Application Reference: 2026/0637

Site Address: 8 Longdale Croft, Smithies, Barnsley, S71 2QT

This application seeks full planning permission for the erection of a single storey rear extension.

PROPOSED REAR ELEVATION
SCALE 1:100 AT A3

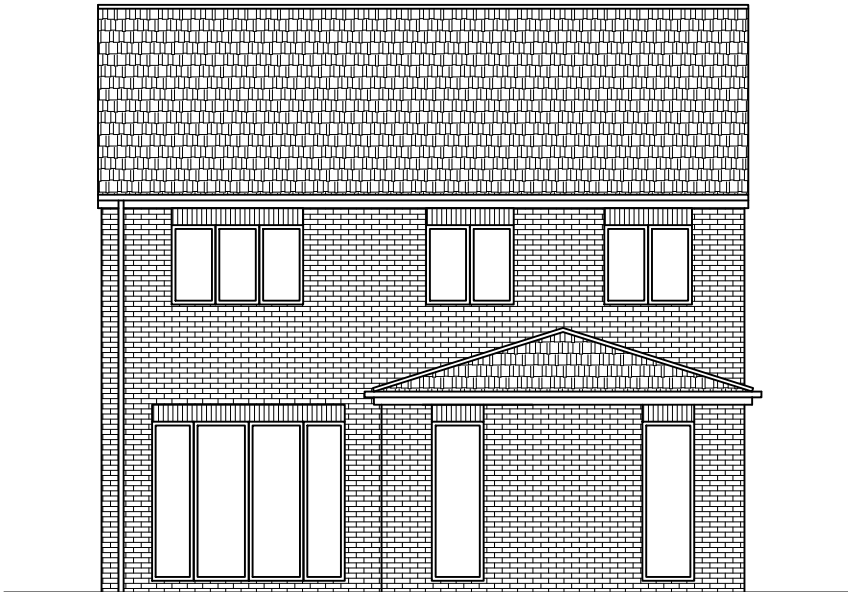
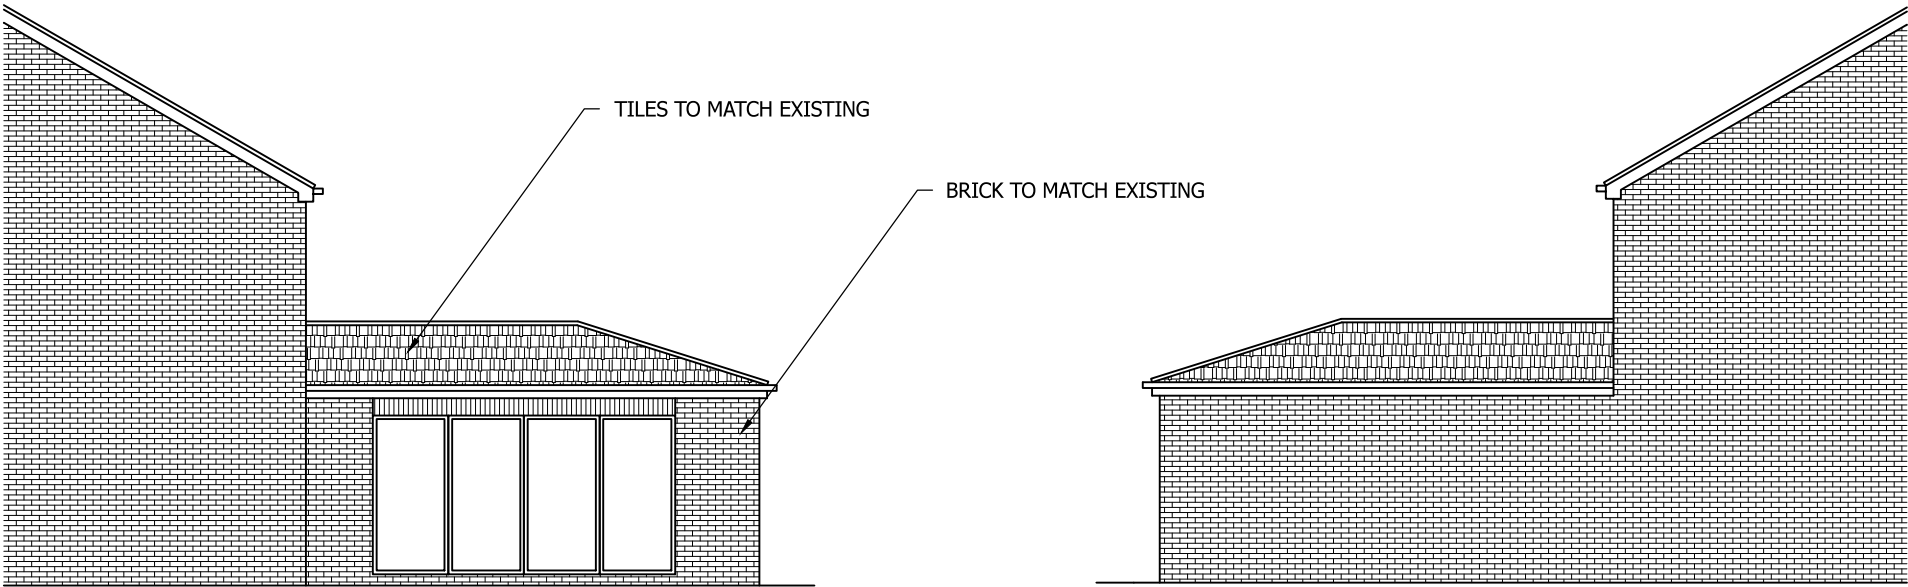
In this instance the proposed extension projects 6m from the rear elevation, and is designed with a height of 2.6m to the eaves and 3.5m to the ridge. The extension is located to the north of the neighbouring property, is set in from the boundary by approximately 1m and as such is not considered to increase levels of overshadowing to an unreasonable level. This carries considerable weight in favour of the application

The design of the proposed rear extension relates well to that of the original dwelling in terms of roof style, pitch and detailing and the materials proposed, in addition the fenestration of the proposed matches that of the original dwelling. This carries considerable weight in favour of the application, and it is therefore considered that the proposed extension is acceptable in terms of visual amenity and in compliance with Local Plan Policy D1.

PROPOSED GROUND FLOOR PLAN  
SCALE 1:100 AT A3

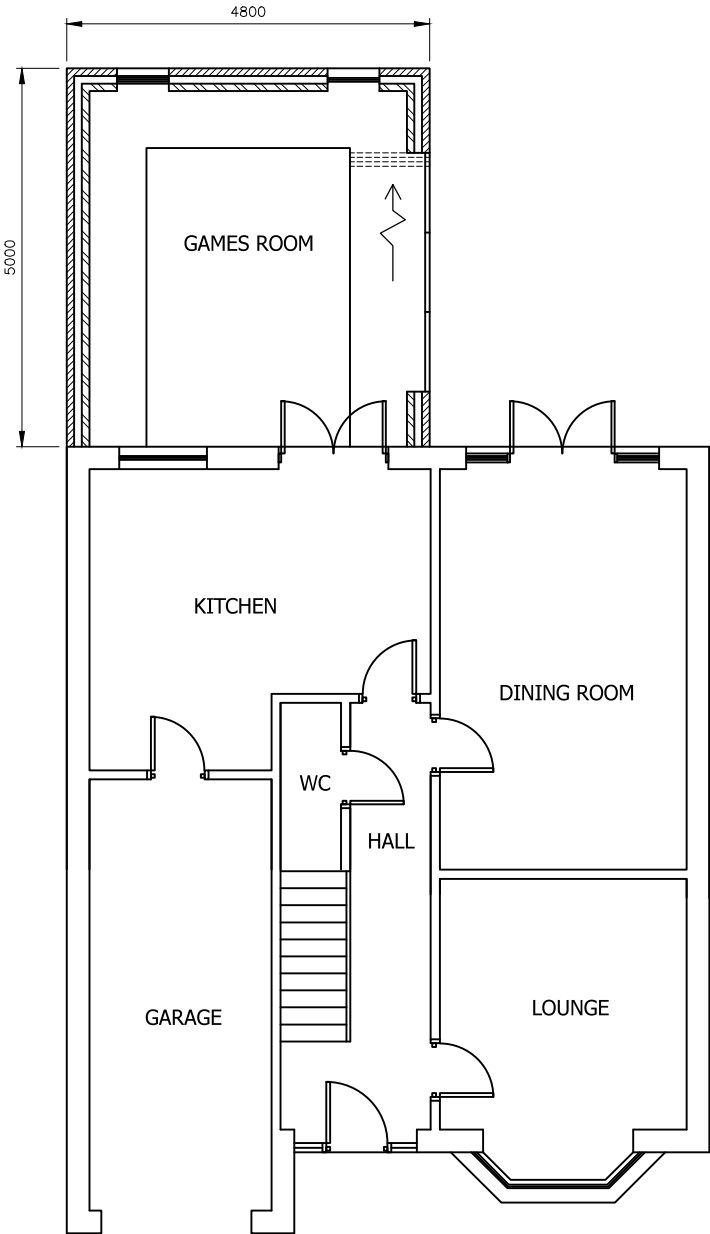
There are no windows on the southern side elevation of the proposed extension and those located on the northern side, and Western rear elevations would face into the garden with the existing boundary treatment providing sufficient screening to limit increasing levels of overlooking to neighbouring properties and their associated amenity spaces.. This carries considerable weight in favour of the application.
